CITY OF ALBUQUERQUE

RE: Tin Can Alley
6100 Alameda NE
Grading & Drainage Plan and Drainage Report
Engineer's Stamp Date: 05/15/19
Hydrology File: C18D086

**RE: Tin Can Alley
6100 Alameda NE
Grading & Drainage Plan and Drainage Report
Engineer's Stamp Date: 04/22/19
Hydrology File: C18D086**

GENERAL NOTES

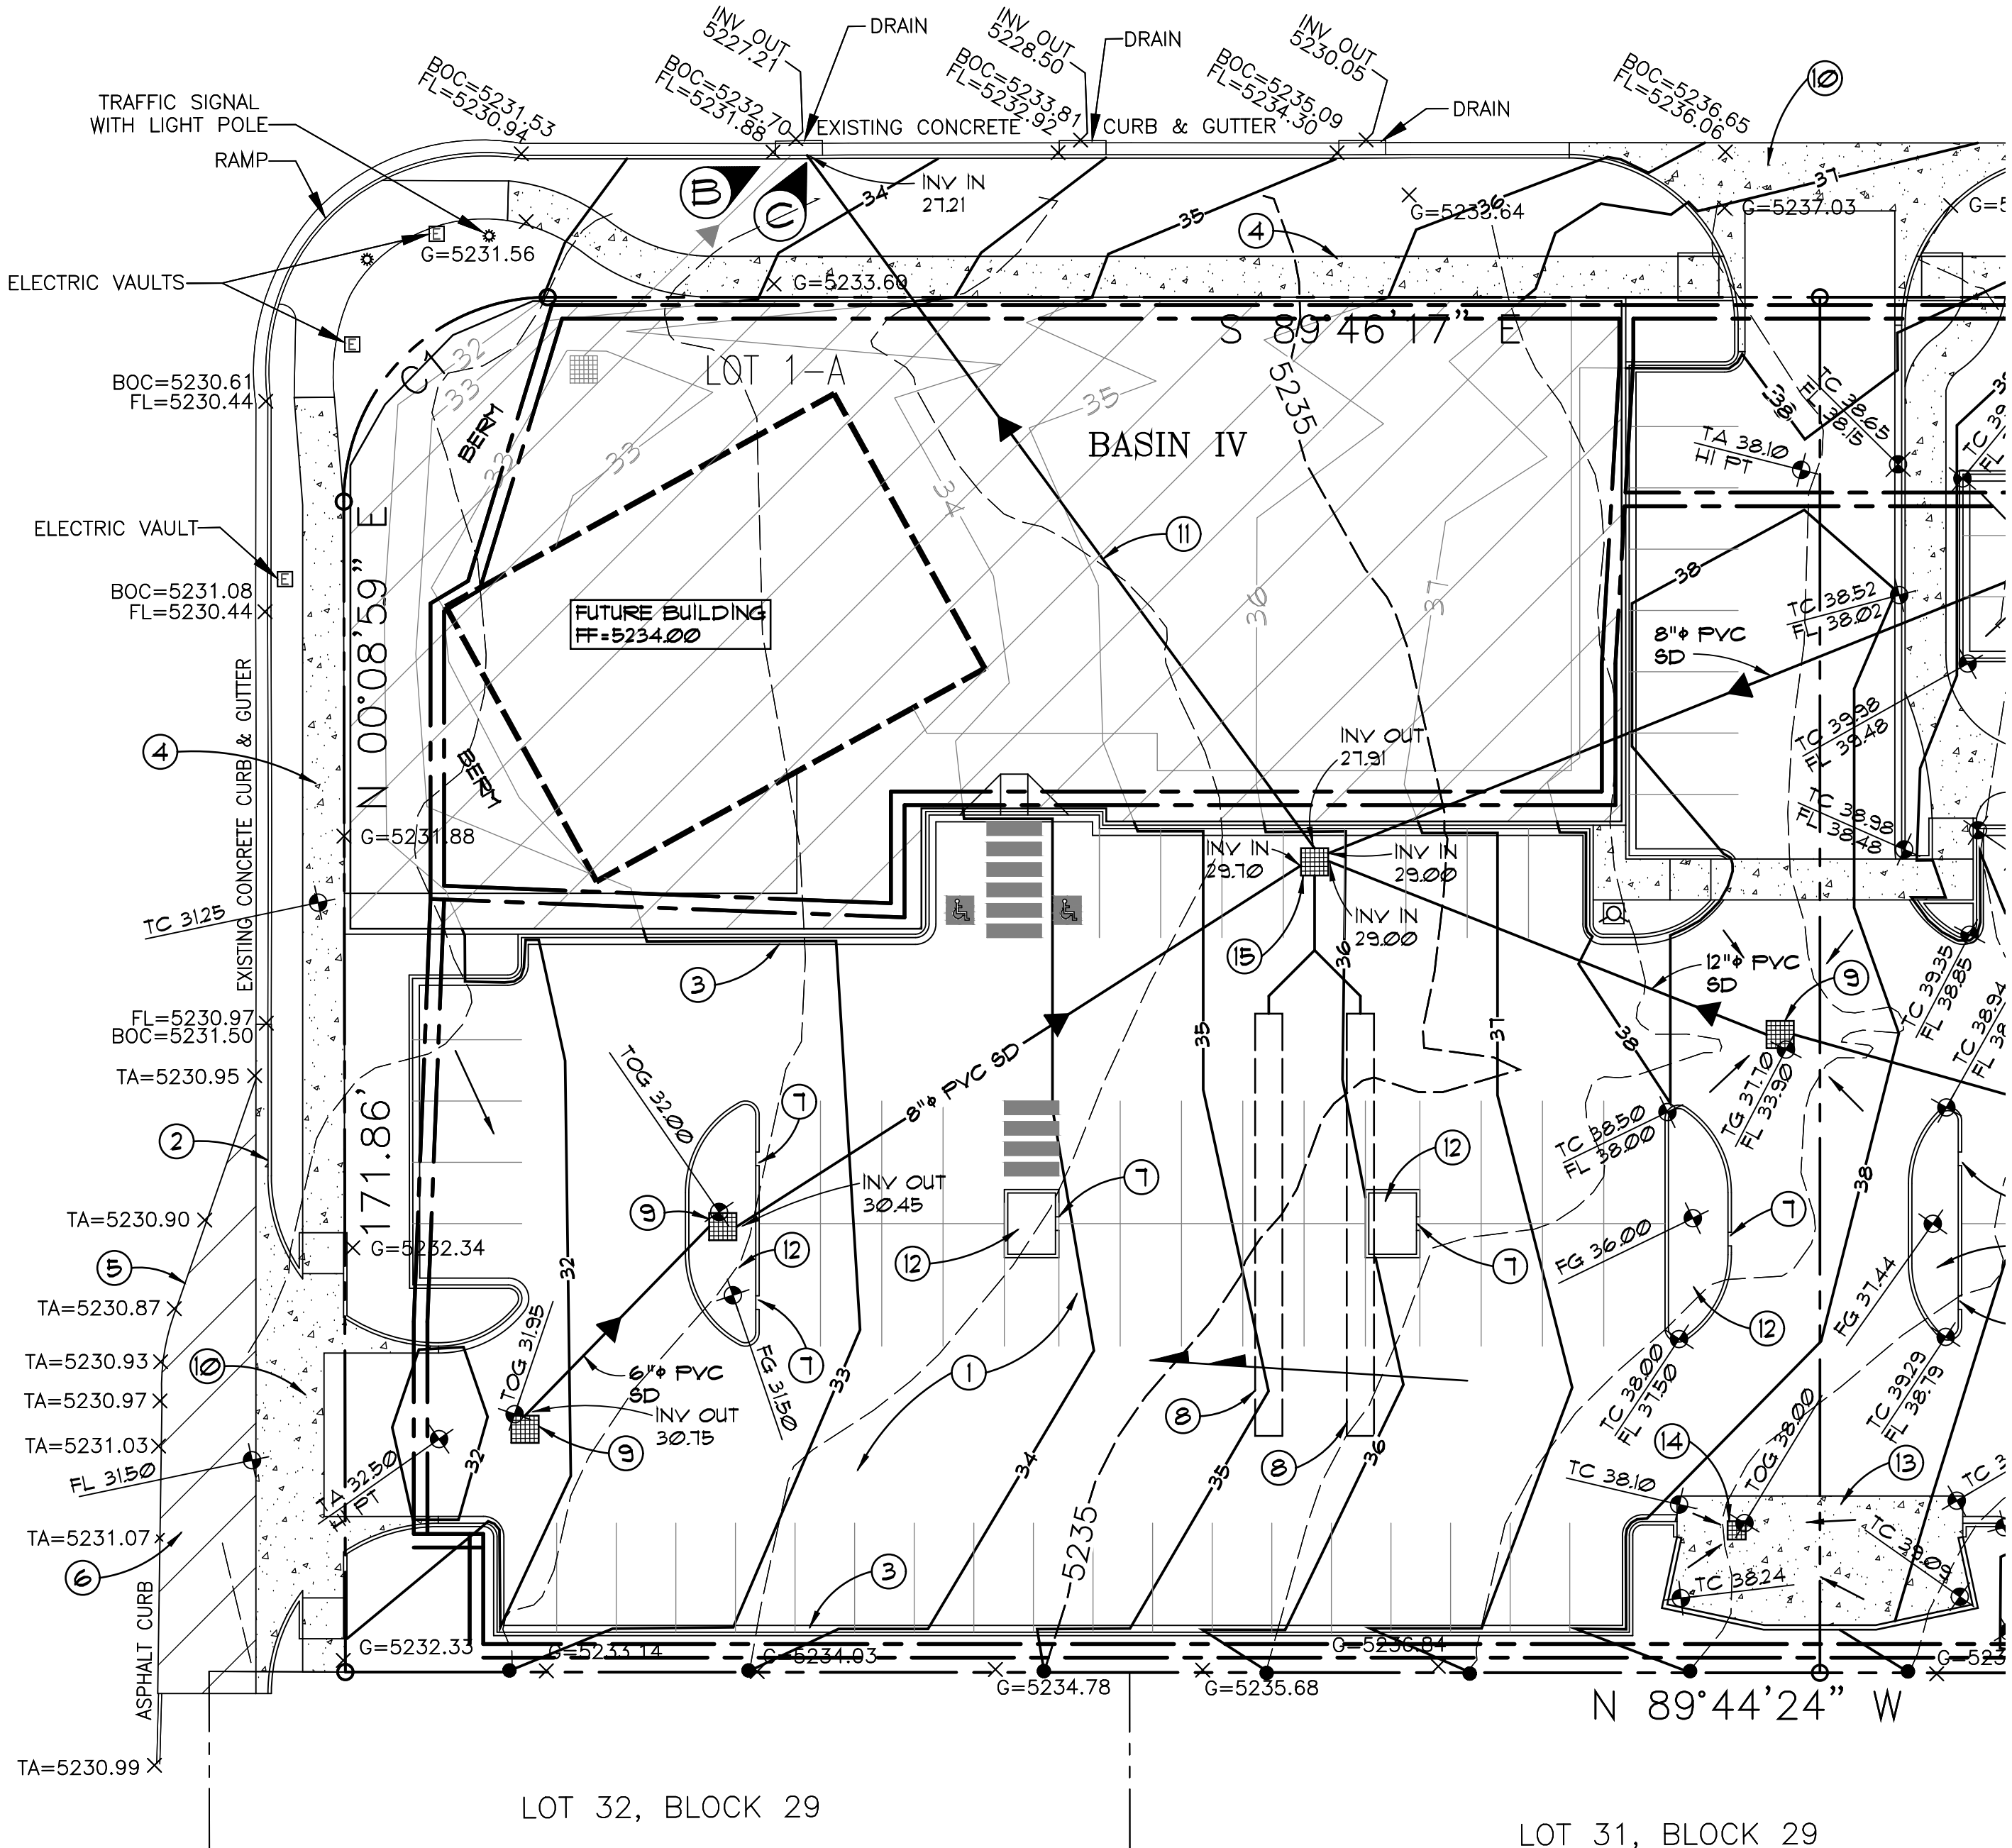
1. The HGL in the manhole in Alameda is 5231.1. Starting here and traveling through the proposed storm system, the HGL at the inlet (note 15) is 35.37 and rim of 35.75. This means that the proposed underground detention and all downstream storm sewer will not be able to discharge into the storm system and will easily go over the waterblock of 32.50 at San Pedro. Therefore, we propose two solutions.

- a. Do a complete study for the installation of inlet(s) on San Pedro along with the upsizing of the existing 48-inch pipe to probably a 60-inch and a manhole. This infrastructure will have to go back to the DRB for a revised Infrastructure List approval. This option seems to be costly and more time consuming so I suggest the second option.

- b. This option eliminates the underground detention facility and installs instead a retention pond along San Pedro for the ultimate development. The total allowable discharge to Alameda is $3.82 \text{ cfs/ac} \times 4.345 \text{ ac} = 16.59 \text{ cfs}$. Basin II is free discharge of 4.37 cfs and a remainder allowable discharge of 12.22 cfs. Basin III & IV have a 100 yr – 6 hr runoff of 15.9 cfs. 15.9 minus 12.2 leaves 3.7 cfs for retention. We will allow for the 100 yr – 6 hr volume to be used instead of the 10 day. So using the DPM, the area for retention is $3.7 \text{ cfs} / 4.49 \text{ cfs/ac} = 0.82 \text{ ac}$. The volume of retention is therefore $2.58'' \text{ (excess type D)} \times 0.82 \text{ ac} = 7,717 \text{ cf}$. Therefore a pond 20' x 80' x 5' (depth) will provide a volume of 8,000 cf. This

pond will be walled with a security fence around it so no one falls in. A waterblock will need to be created at the curb return just to the east of the proposed underground detention. (Location provided on plans) Basin III will stop at this waterblock and Basin IV will extend to the south. Not only does the underground detention facility be eliminated, but two additional inlets and pipes are eliminated as well. (Marked on the plans) The inlet just to the east of the new waterblock, needs to be lowered a bit. This maybe lowered to say TG 37.50. (Please check to ensure that this is enough so that the runoff does not just go over the new waterblock) From this inlet, the outflow pipe can then connect to the most easterly of the existing three inlets. This pipe should be able to discharge the allowable 12.22 cfs. The only other new pipe is from the inlet by the San Pedro entrance and goes to the retention pond. This option also has the benefit of lowering the elected Payment-in-Lieu amount. Please verify the correct amount. By my calculation, for 0.82 ac @ 90% impervious will need a stormwater quality volume of 910 cf. Since this will be handled within the required retention pond volume it can be subtracted from the site's deficit volume amount. The total site stormwater quality volume is 3655 cf – 1155 cf (provided) – 910 cf (retention pond) = 1,590 cf. The Payment-in-Lieu amount is 1590 cf * \$8/cf = \$12,720. This is a savings of \$7,280. Along with the savings of the revised storm sewer system, this is a better option than the first one.

2. Please reflect the Grading and Drainage Plans for whichever option that you chose.
3. Please reflect the Drainage Report for whichever option that you chose.
4. Please add the calculations for the temporary retention pond to the Drainage Report.

1. Following your recommendations we have eliminated the underground storage facility for storm water runoff and have designed a Retention Pond that will hold runoff from the western end of the Alameda Mixed Use project. The drainage basins have been revised to account for this change as have the runoff calculations for the affected basins.
2. Grading and Drainage Plans for project have been modified to reflect the recommended changes.
3. The Drainage Report has been revised to reflect the design changes recommended.
4. Temporary pond volume calculations have been added to the Drainage Report and slight modifications to this pond are reflected on the drawing.
